From: Simon Davis
Sent: 11 December 2018 14:20
To: [REDACTED]
Subject: FW: P/108/18/PL - Church Farm Holiday Village, Pagham

From: Fiona Fitzgerald
Sent: 11 December 2018 12:13
To: Planning.Responses <Planning.Responses@arun.gov.uk>
Cc: Simon Davis <Simon.Davis@arun.gov.uk>
Subject: P/108/18/PL

Proposed Housekeeping Building - Proposed Housekeeping Plan, Elevations & Section A-A

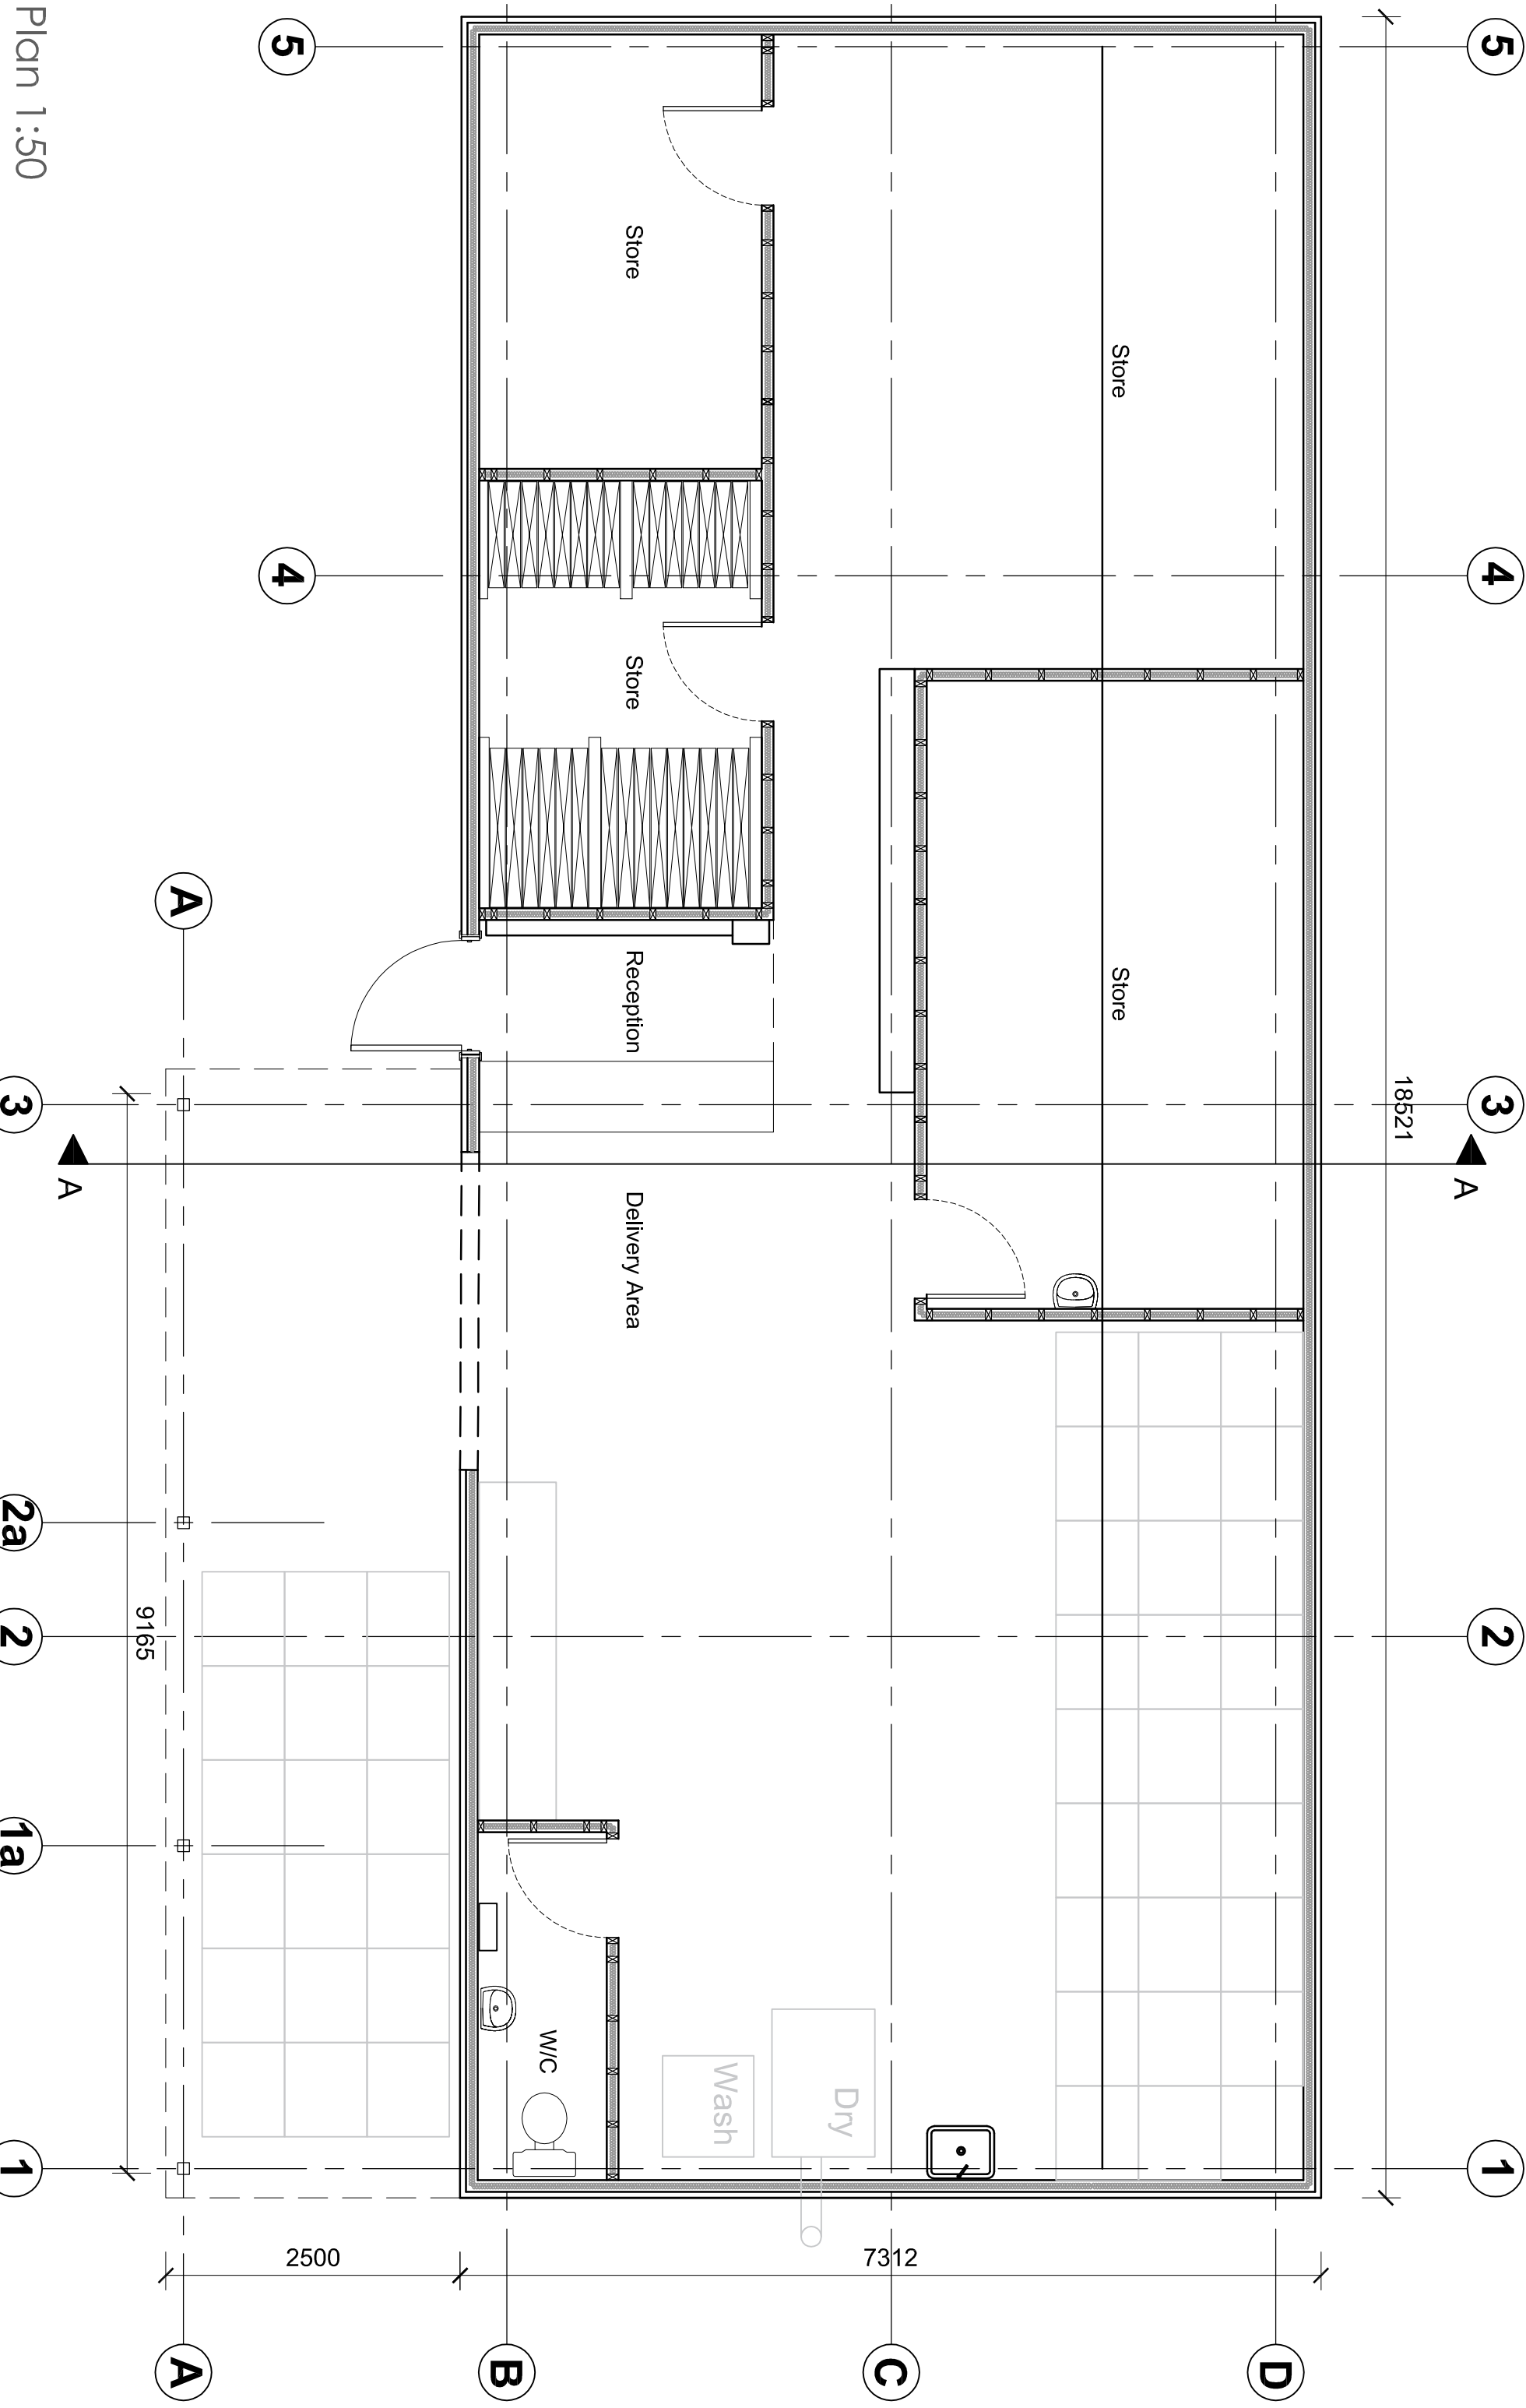
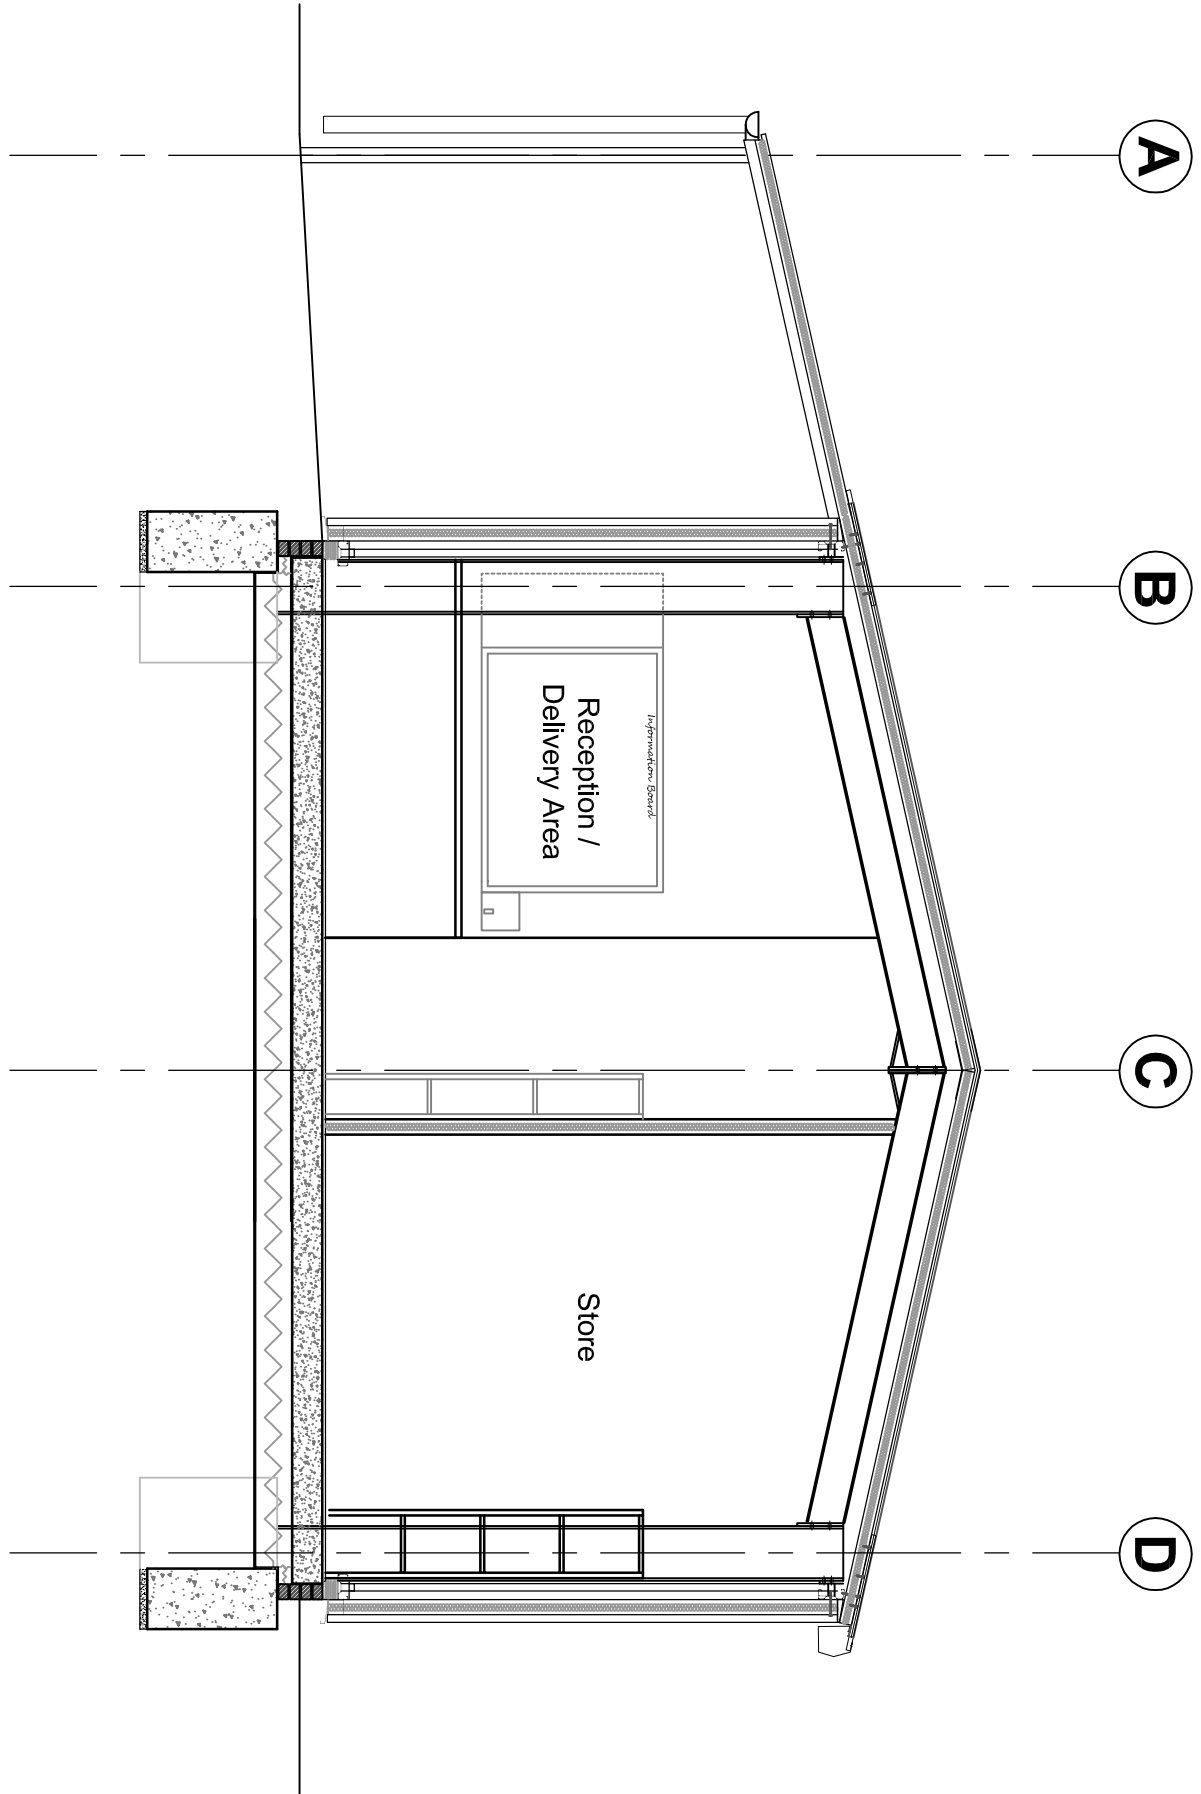
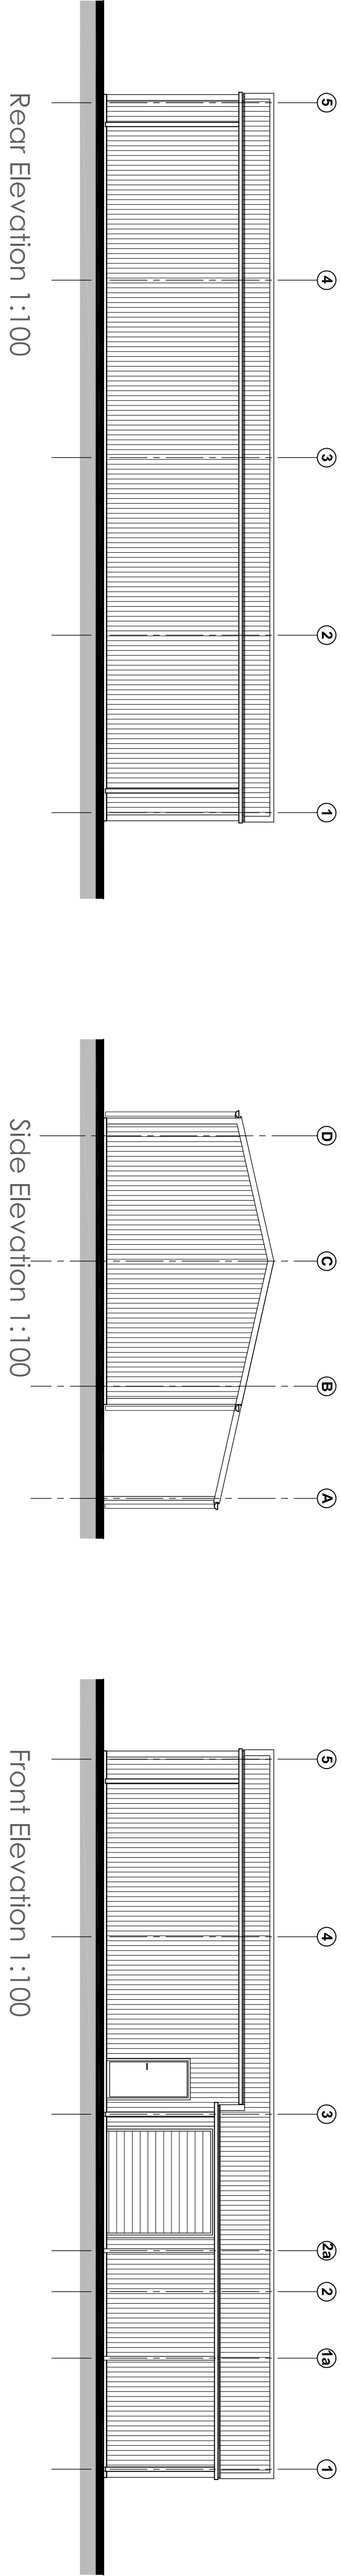
1. If there are any planned hours of use of the new building? I am aware that historically we have had a number of noise complaints from local residents and am keen to understand whether there are any noise implications from the use of the building.
2. Is there any intention of keeping food in the building? I am referring to food for the use of the site, not staff sandwiches! Should food for the site be stored in the building, there would be an issue with the sanitary facilities as there is only one door leading from the toilet and no lobby.
